12 December 2019

Jason Maslen
School Infrastructure Assessments
Department of Planning & Environment
GPO Box 39
SYDNEY NSW 2001

Re: Submission- New Estella Public School, Wagga Wagga Estella (SSD 9494)

WAGGA WAGGA PS
ESTELLA ROAD, ESTELLA, NSW, 2678
NEW HIGH QUALITY CLASSROOMS PACKAGE 2
DRAWING NAME
FENCING PLAN & DETAILS

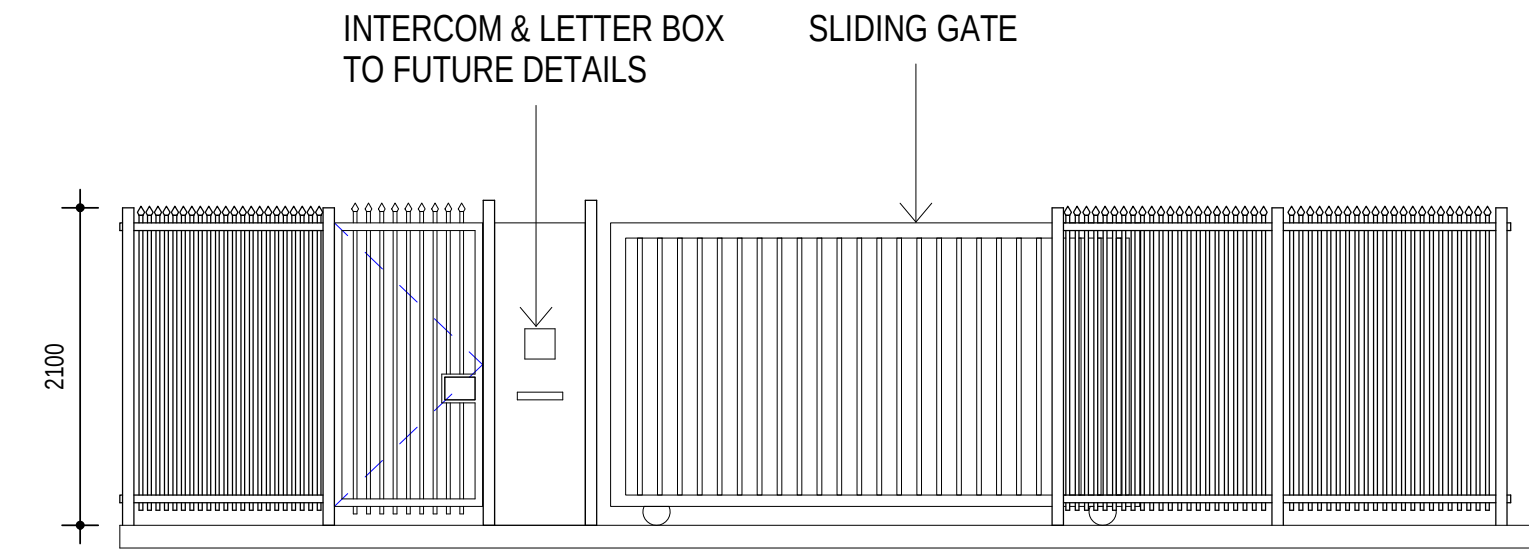
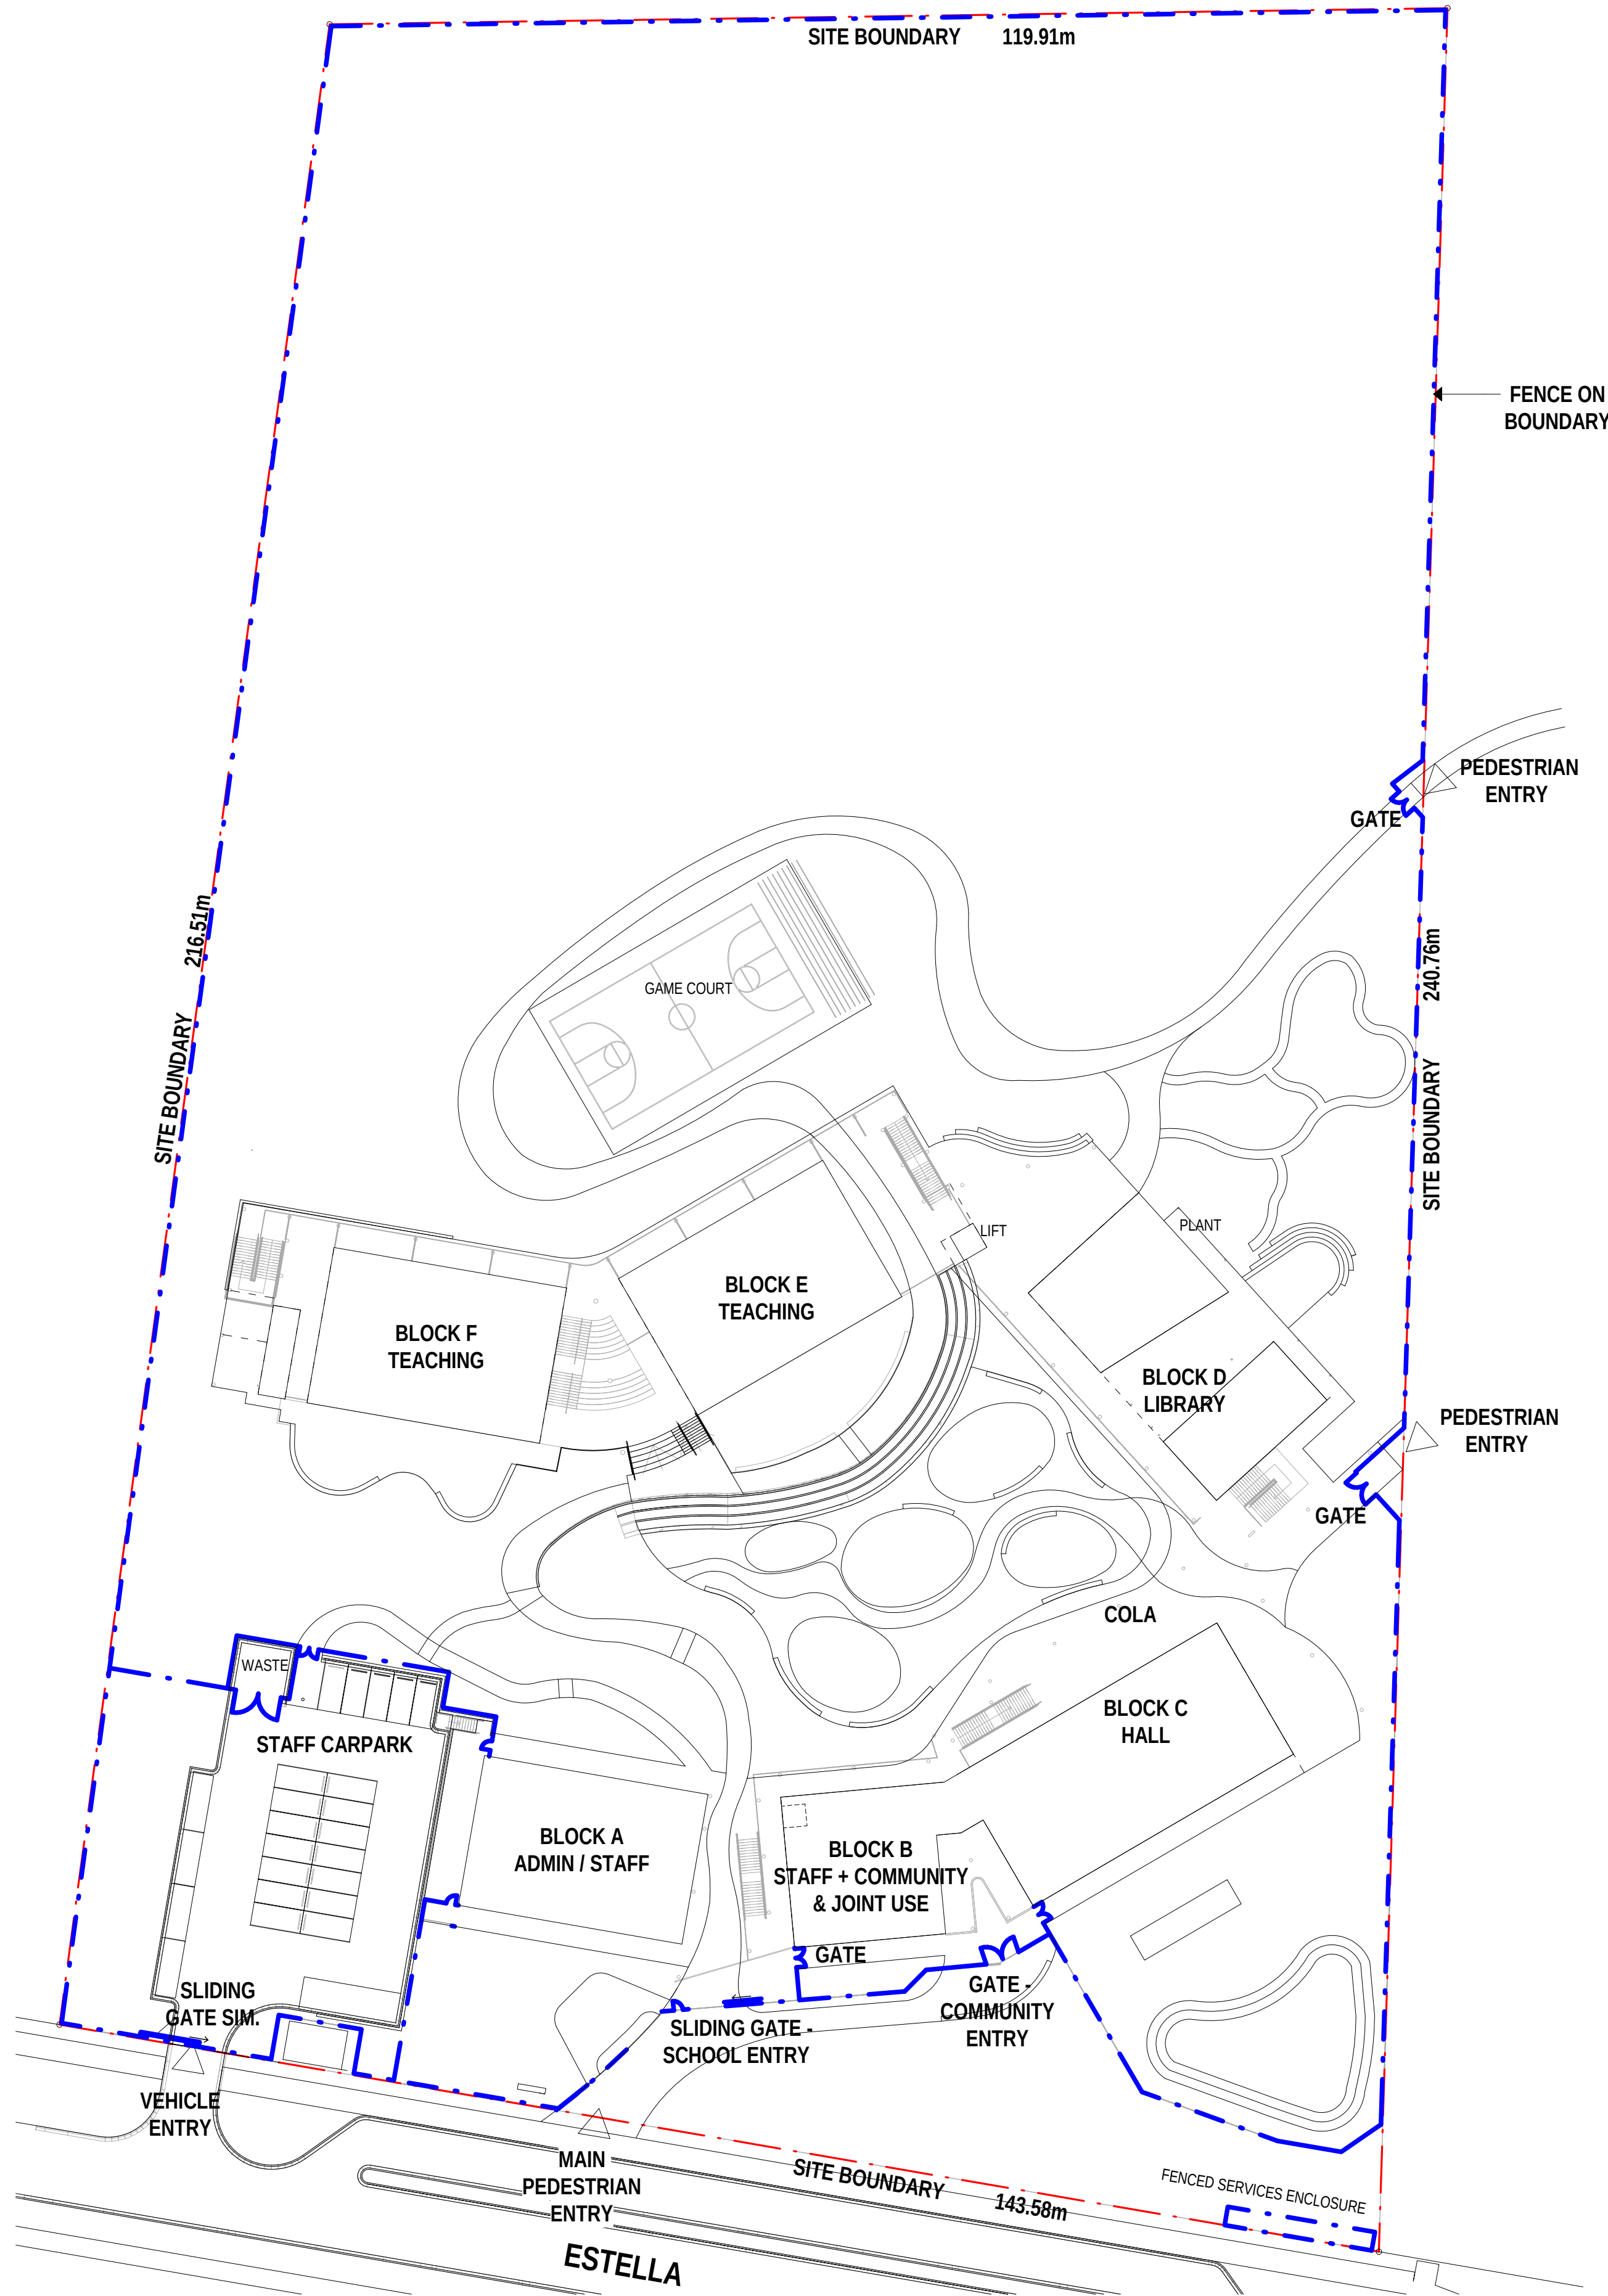
The design lacks linkage to the Yindyamarra Reconciliation site to the west and north-west.
